# **SCOPING OPINION:**

## Proposed Sea Link

**Case Reference: EN020026**

**01 December 2022**

Scheme: SEA LINK  
 Document Title: STATUTORY DESIGNATED ECOLOGICAL FEATURES - SHEET 1 OF 5

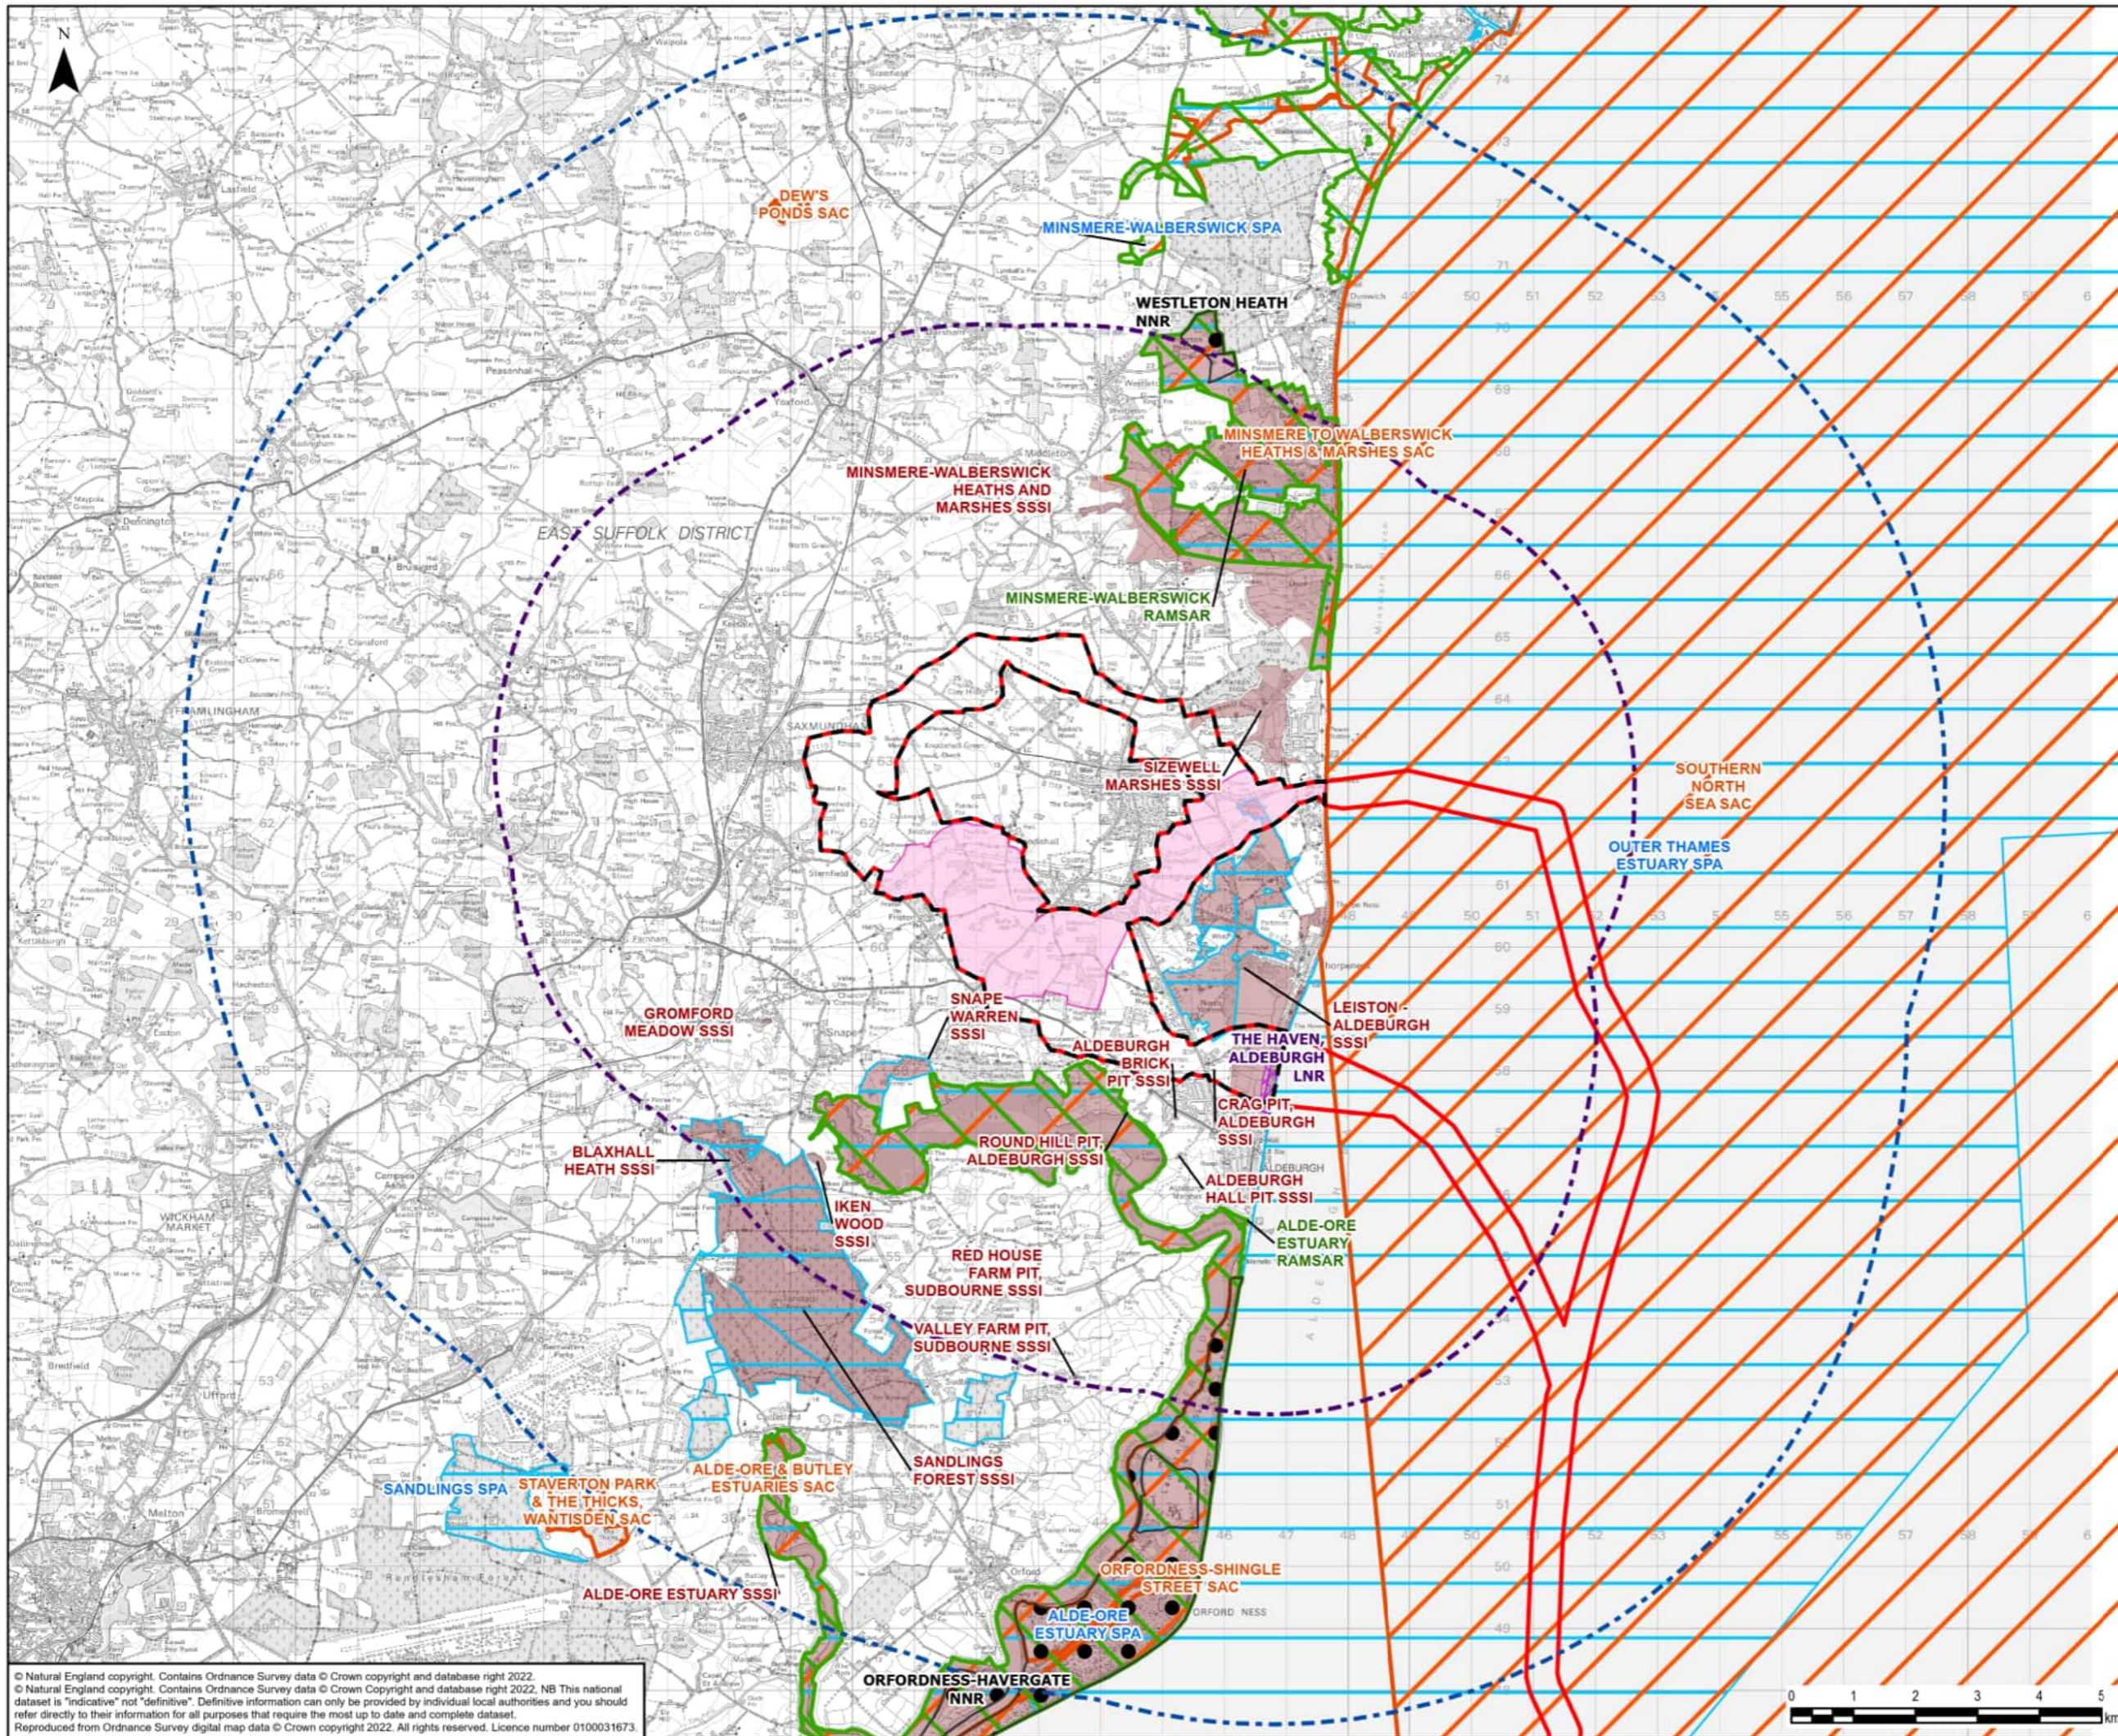
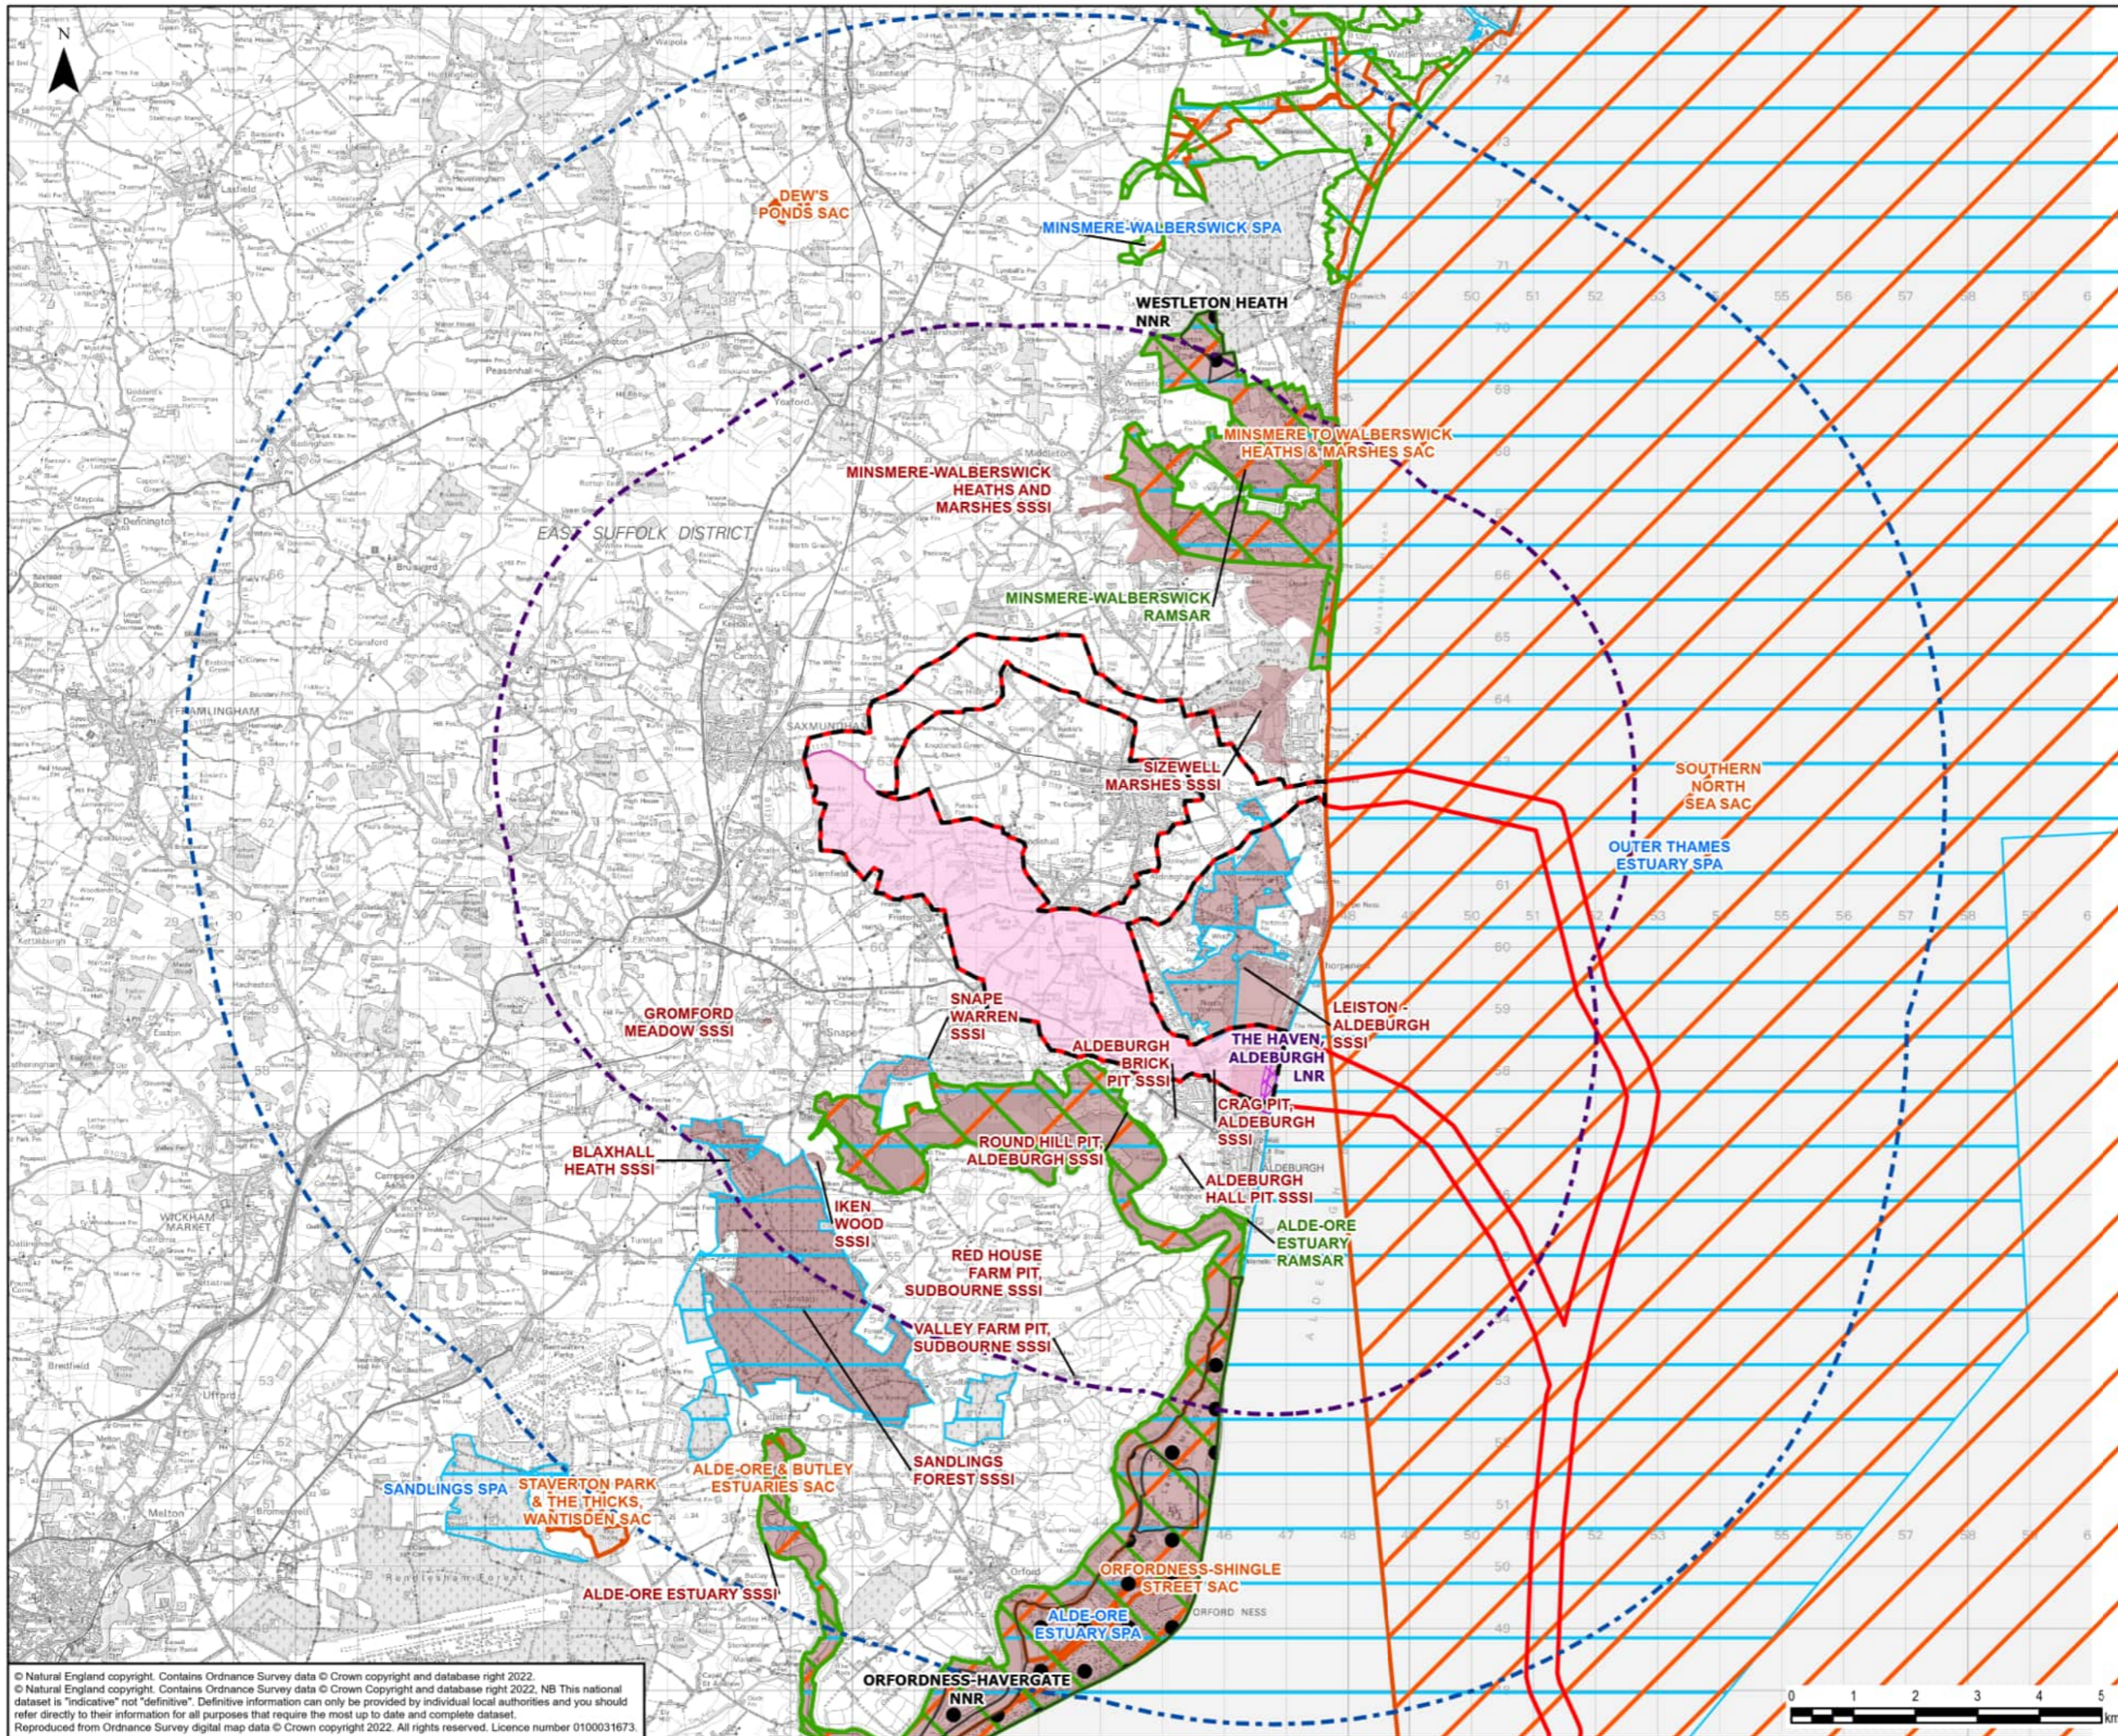
ID	Ref	Description	Inspectorate's comments
3.2.2	Volume 3, Figure 2.3.1	Figures	The location and extent of Sandlings SPA is not clear from Figure 2.3.1. Figures accompanying ES should clearly show and label the location and extent of designated sites.
